CITY OF ALBUQUERQUE

June 16, 2025

Re: Venice Volleyball Facility
5801 Venice Ave. NE
30-Day 2nd Temporary Certificate of Occupancy
Transportation Development Final Inspection
Architect's Stamp dated 02-26-24 (B18-D022)
Certification dated 03-31-2025

TRAFFIC CIRCULATION LAYOUT

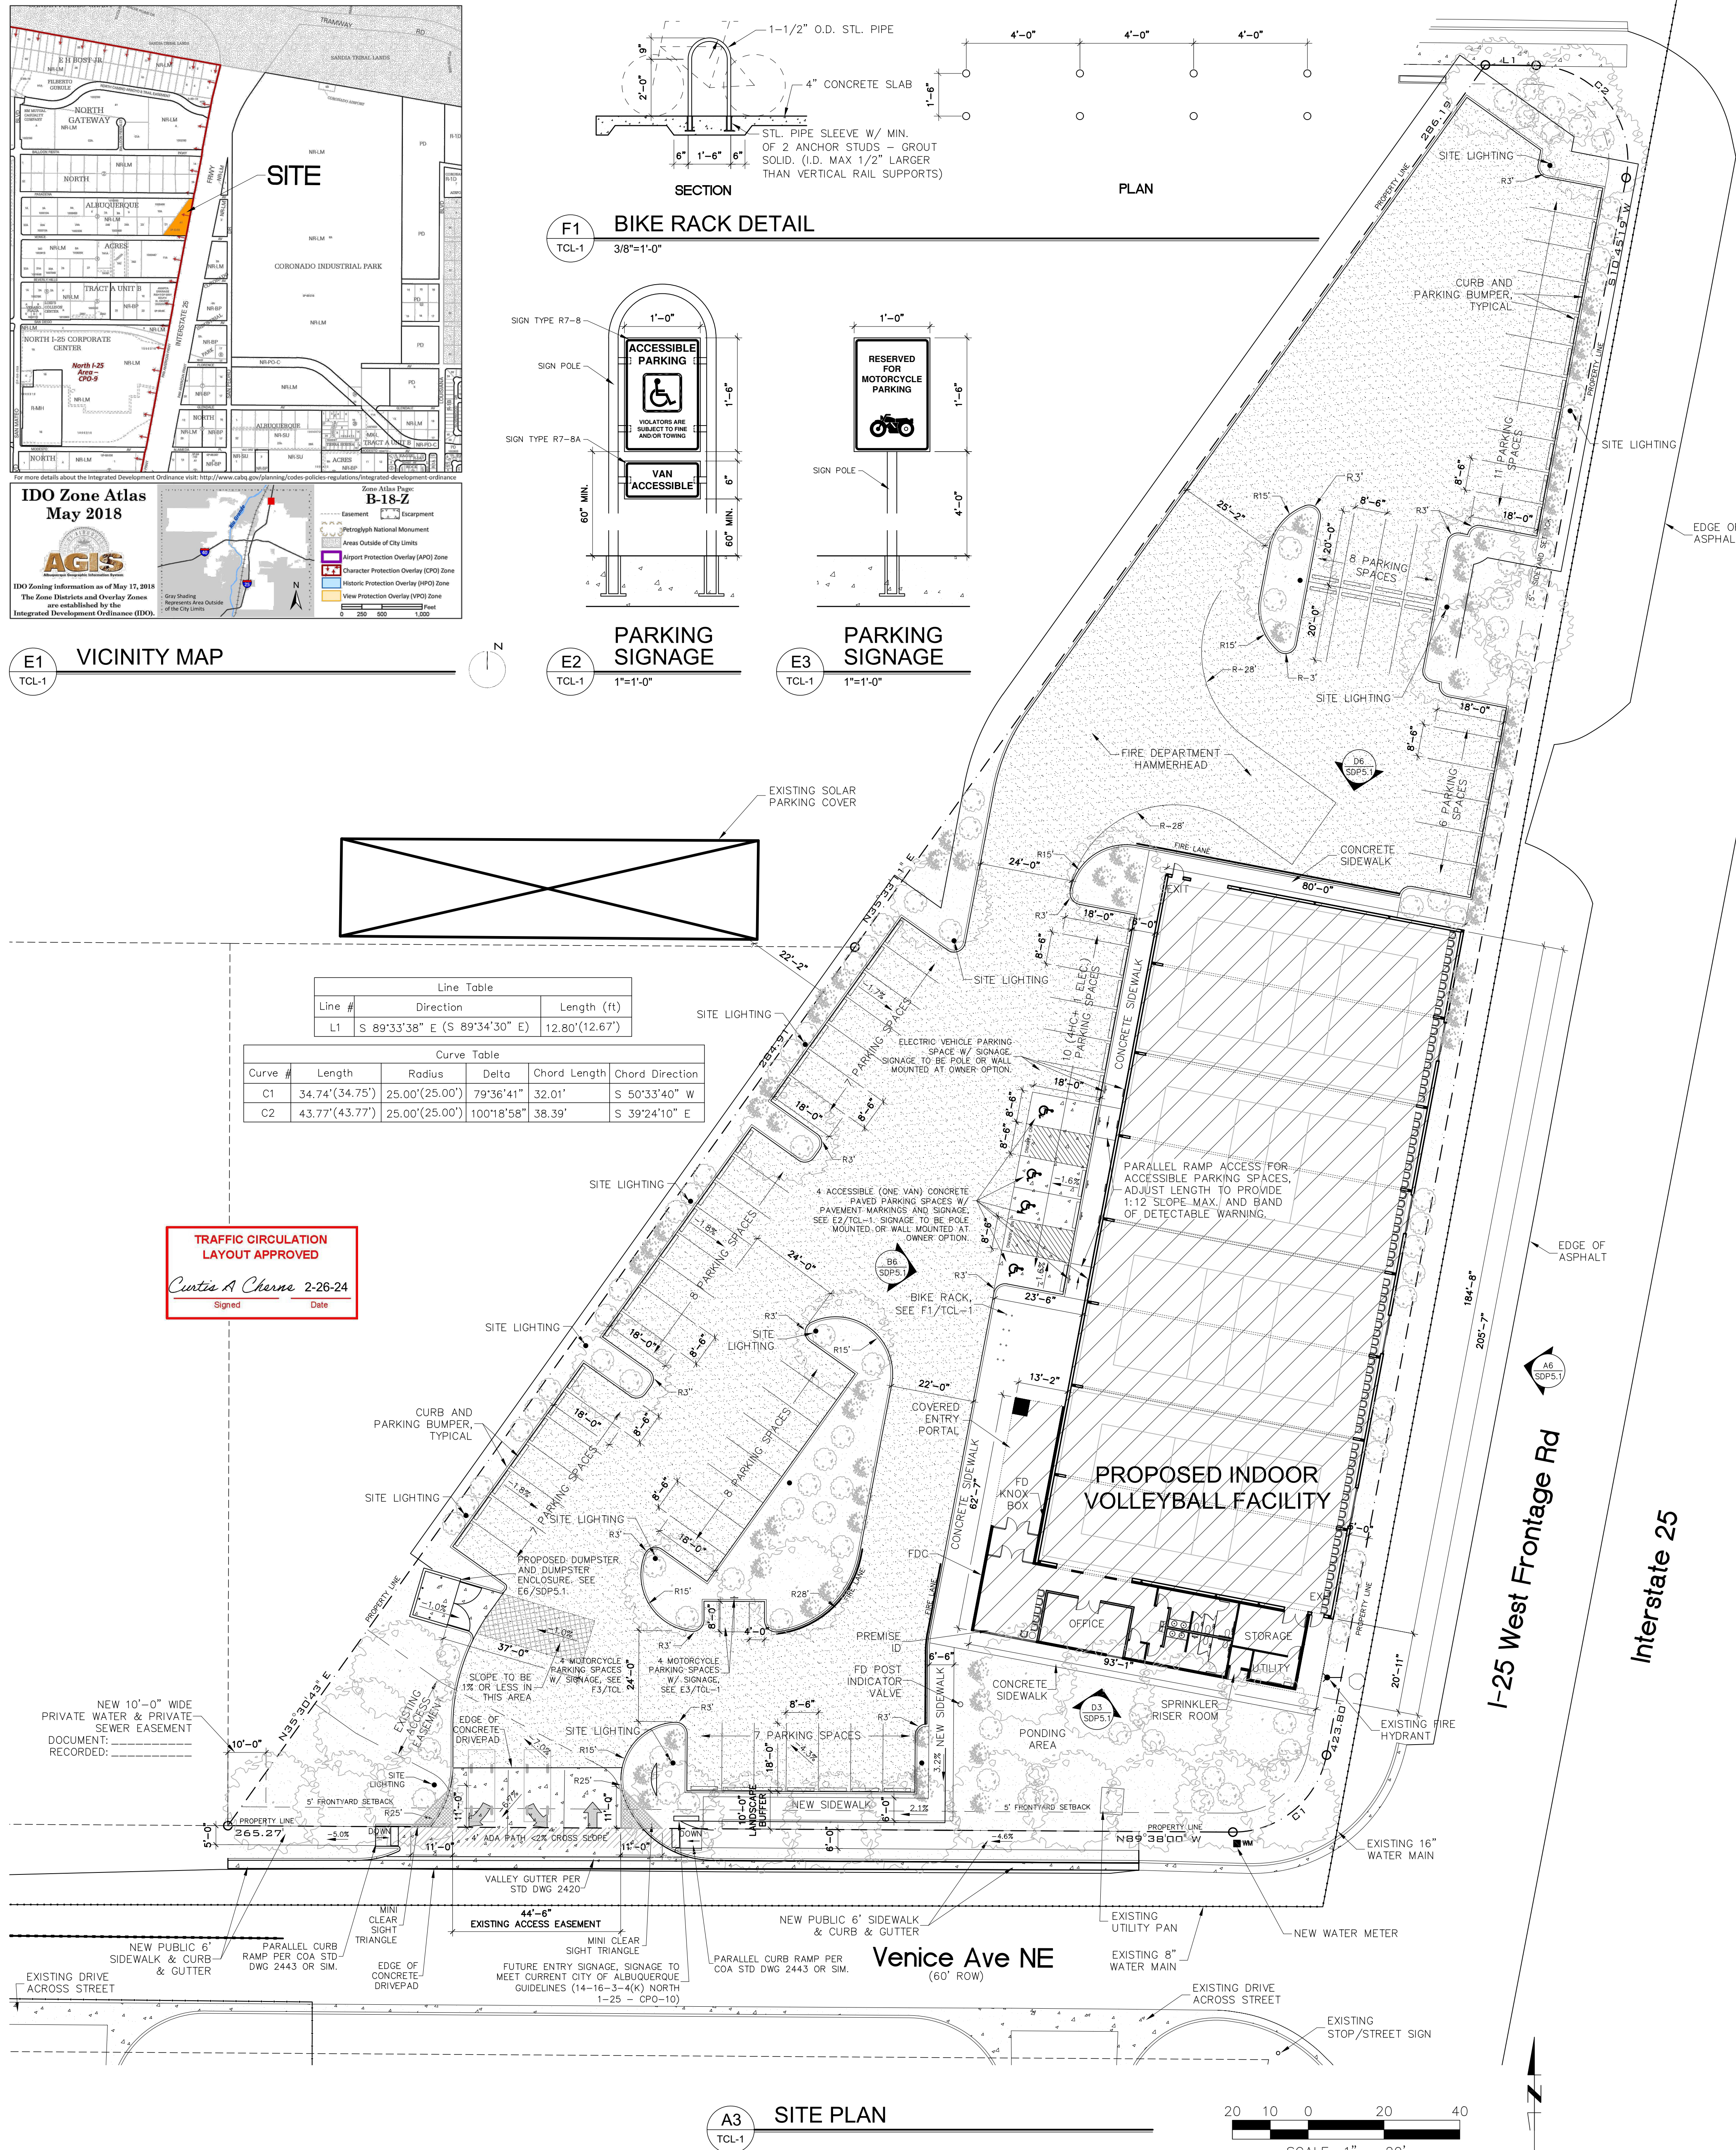
1. Per approved site plan a curb along the north and west side of the site must be constructed.
2. One of the ADA parking spaces must be designated as a Van accessible space. Please provide a "Van" sign at that space.
3. Per approved site plan and city requirement, please install the "U" shape Bike rack following the required dimensions.
